From: Alison Meeus [redacted]
Sent: 29 April 2014 15:41
To: Simon Davis
Subject: RE: Planning Application Y/22/14

I've received your comments re the Kings Close, Yapton application – thank you. However, I've had a request from the Parish Council to say:

PROPOSED ACCESS IMPROVEMENTS - scale 1:250

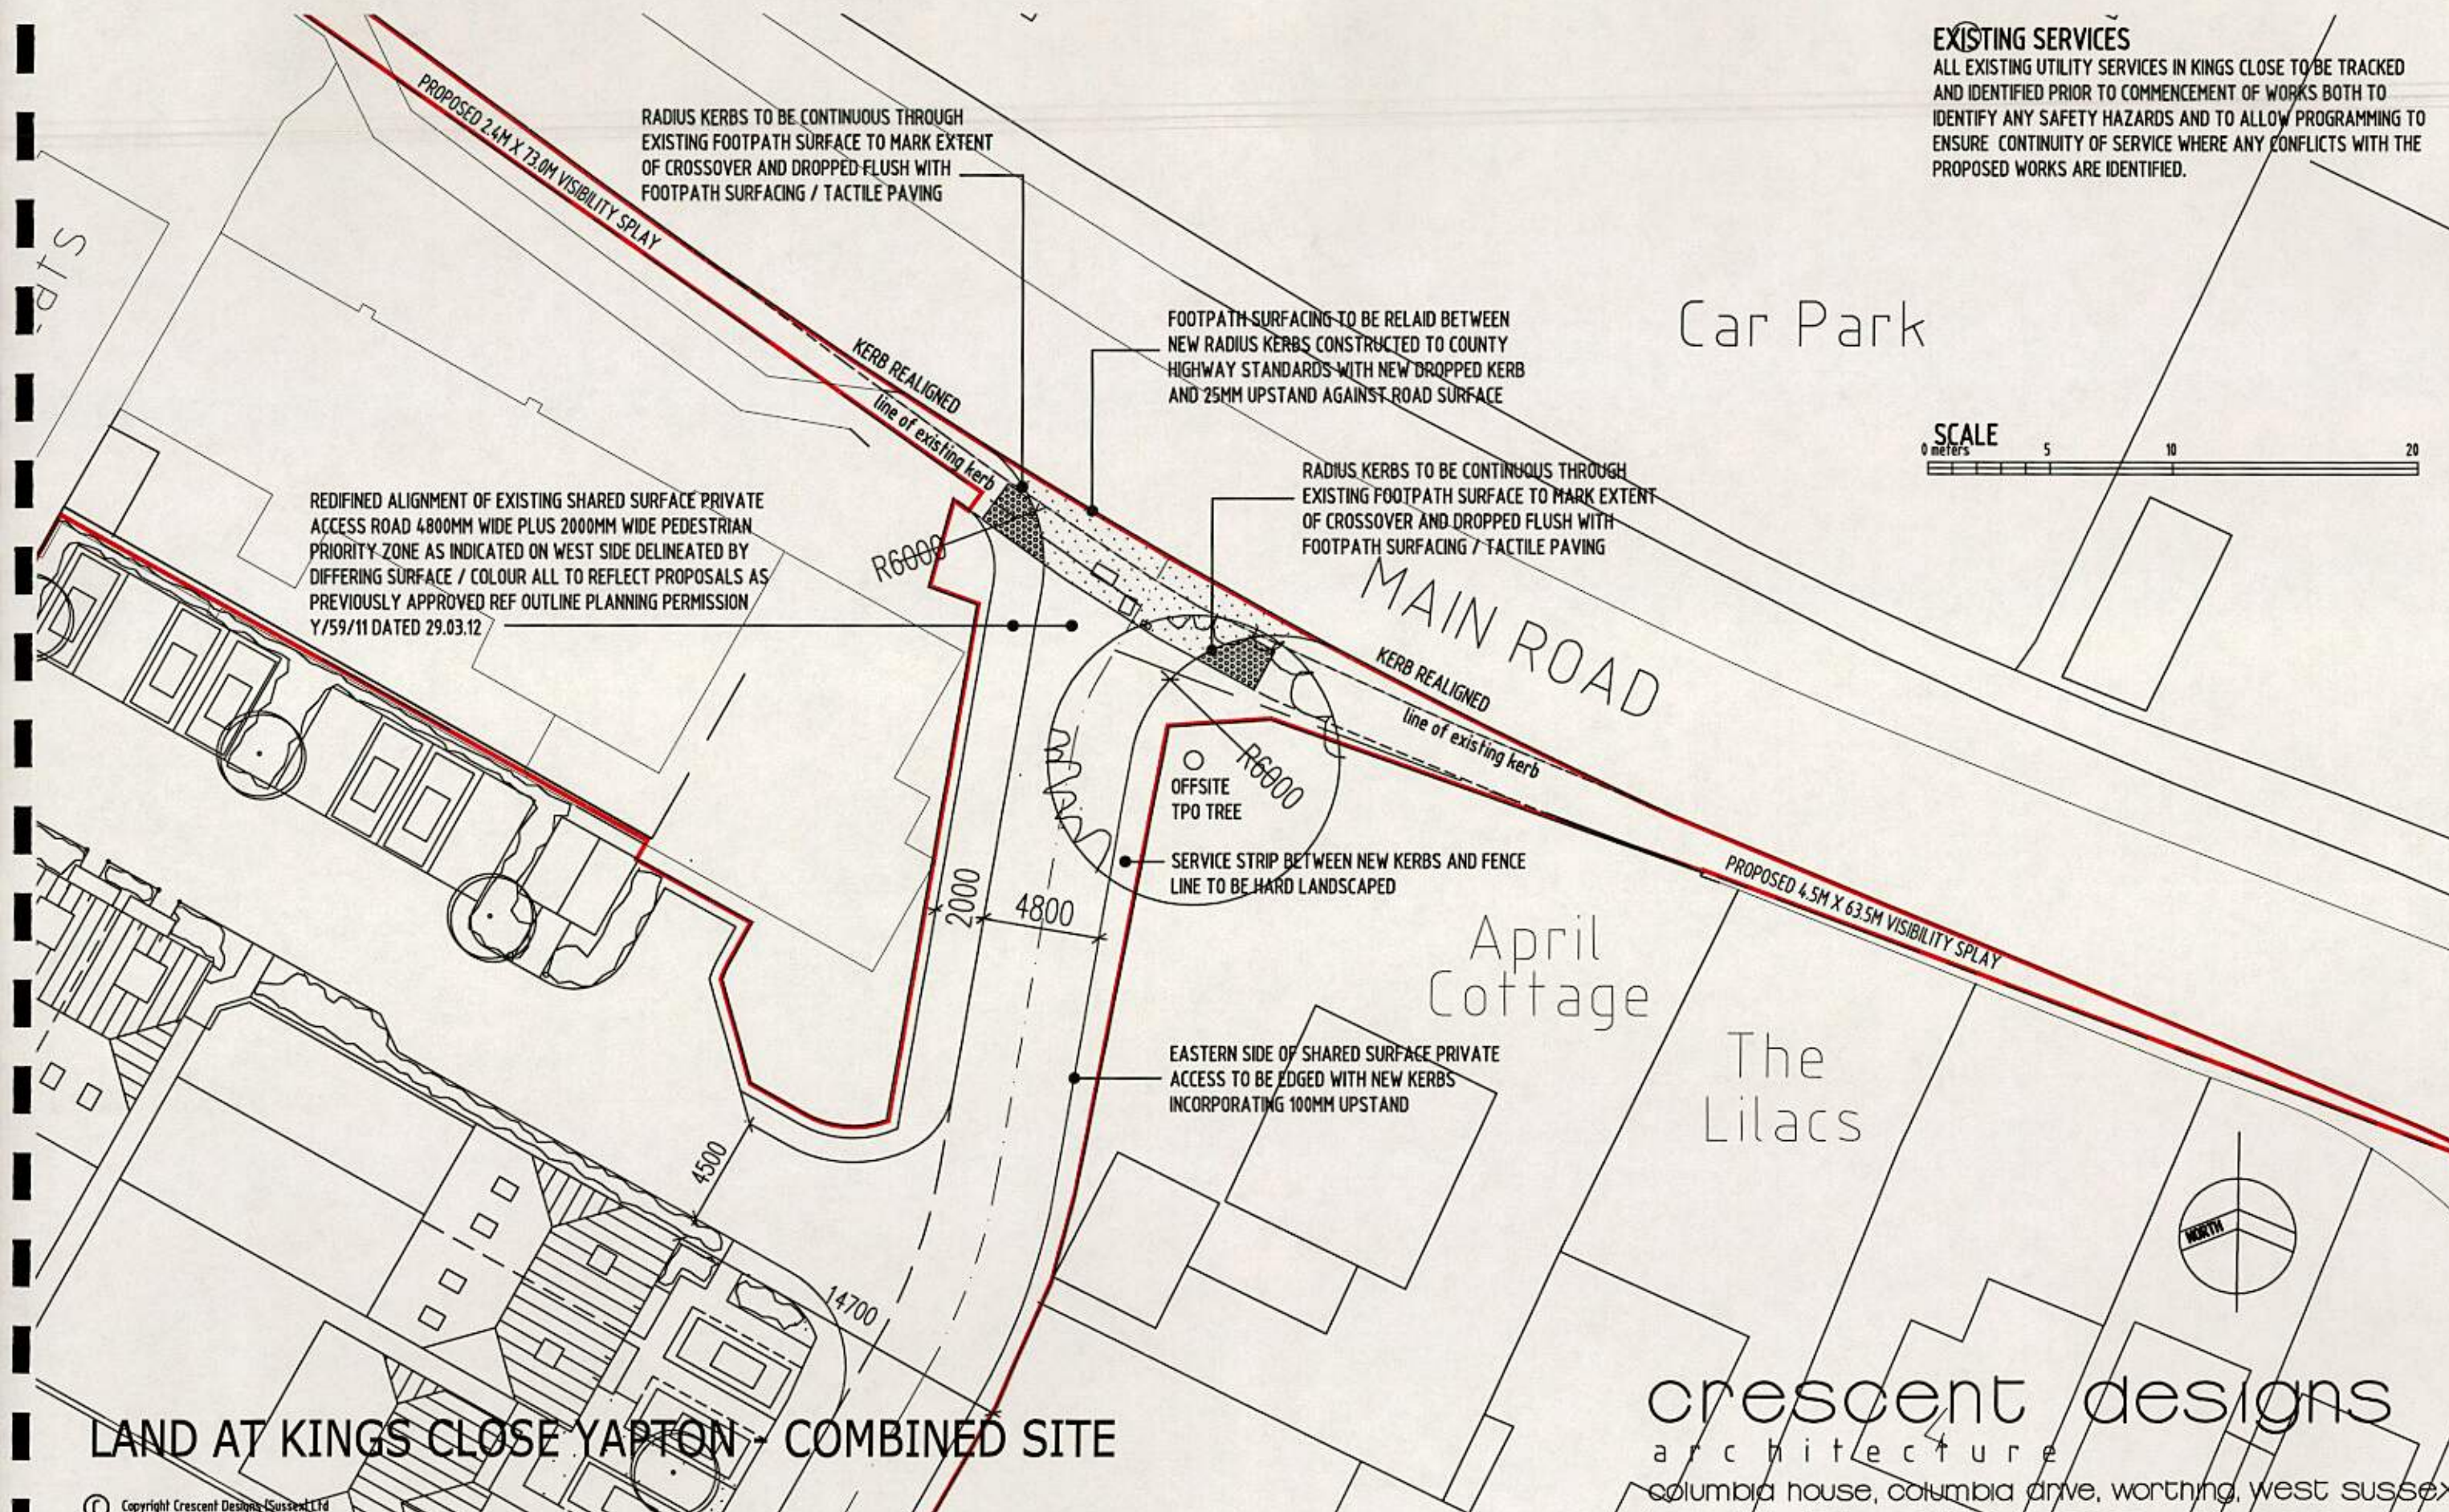
"I have just forwarded to Arun under separate cover using the online system the Parish Council's comments with regard to this application (I've not got these yet – SD). Attached is a photo which illustrates the problem which we have discussed with WSCC Highways (Ben Whiffin). Ben is proposing to reinstall bollards to discourage parking but in the past this has not proved much of a deterrent and it would probably be best is the pavement could be raised at this point as part of the highway works connected to the development.

I'm not sure that it is fair to request works to the front of COOP from the Yapton Close applicants but I'd be grateful for your thoughts, even if just agreeing with me. I also think that raising the kerb height to the height elsewhere in the street wouldn't stop people parking there as the local kerb height would still allow cars to drive up it (and a much higher kerb height would look out of place and not be suitable for pedestrians)

I have just forwarded to Arun under separate cover using the online system the Parish Council's comments with regard to this application. Attached is a photo which illustrates the problem which we have discussed with WSCC Highways (Ben Whiffin). Ben is proposing to reinstall bollards to discourage parking but in the past this has not proved much of a deterrent and it would probably be best if the pavement could be raised at this point as part of the highway works connected to the development.

I agree that a kerb wont discourage parking. I was wondering how the co-op is serviced and if this dropped kerb is used by them for this purpose anyway, its not ideal but I don't think cars parking here will obstruct visibility completely, or cause any unsafe practice especially as the obstacle is in the leading direction. Alison
